Your Ref: OWPC1417
Our Ref: FG/132/13/ 10-10-2013
Please ask for:
Mr D Sullivan

18th November 2013

Erection of single storey detached garage/workshop
29 The Poplars Ferring

Client:		Drawing Title:	
Andrew Mackinnon		Proposed floor & roof	
29 The Poplars		plans & elevations	
Ferring		Drg No:	
Proposed Work:		Rev:	
Proposed detached		POPLAR 01	
garage & workshop		Scale:	
		1:100@A3	
		Drawn:	
		07.10.13

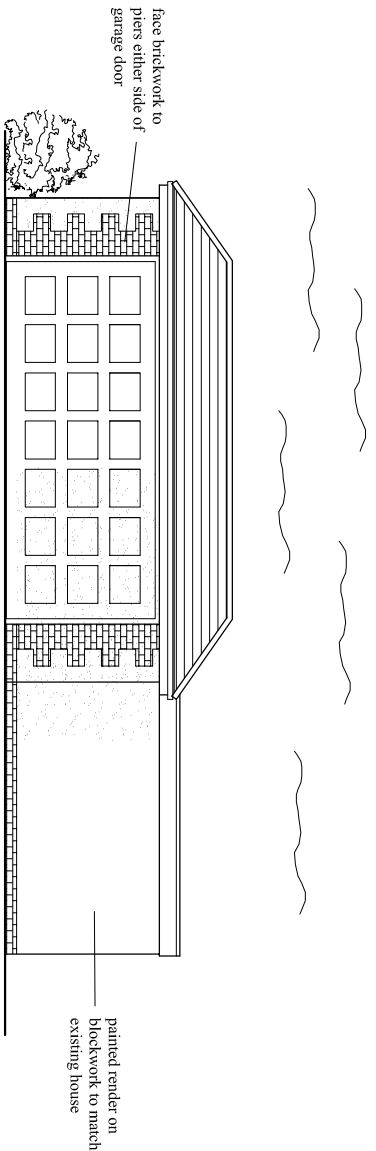
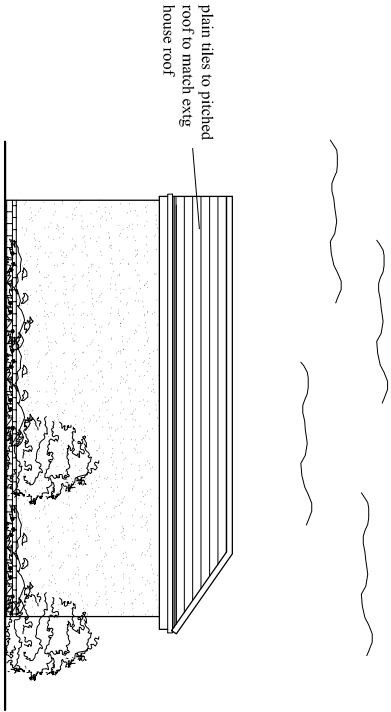
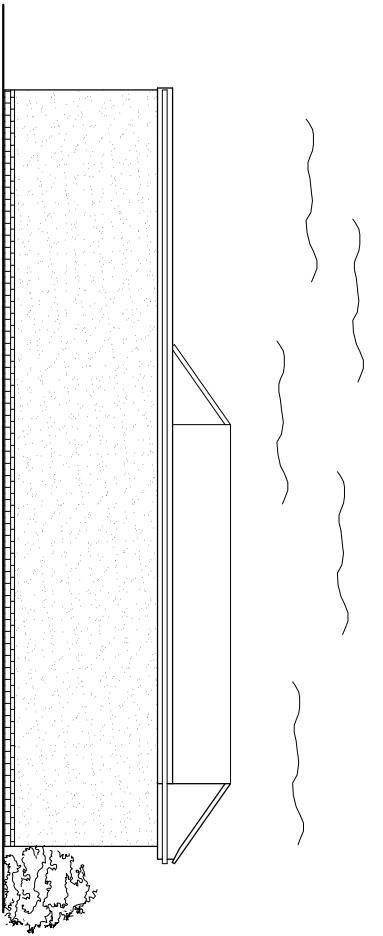
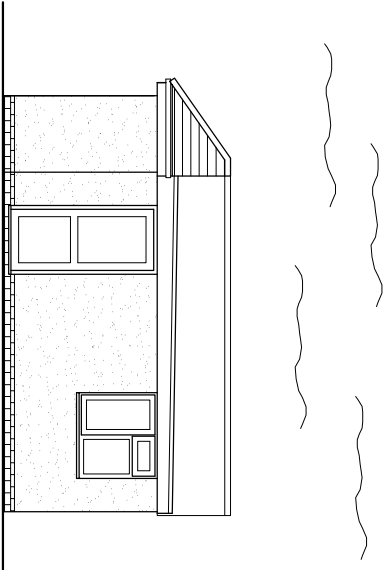
My garden backs on to the rear of the proposed garage / workshop. My immediate concern is that a considerable amount of my natural light will be blocked out by this structure. The existing plans only show the proposed footprint dimensions and offer no information as to the height of the proposed structure, at either the front or the rear. Please could you provide detailed plans which include this essential information. Without this information I can only object to the application, however my initial concern is that a garage and workshop of this size is totally out of keeping with the area.
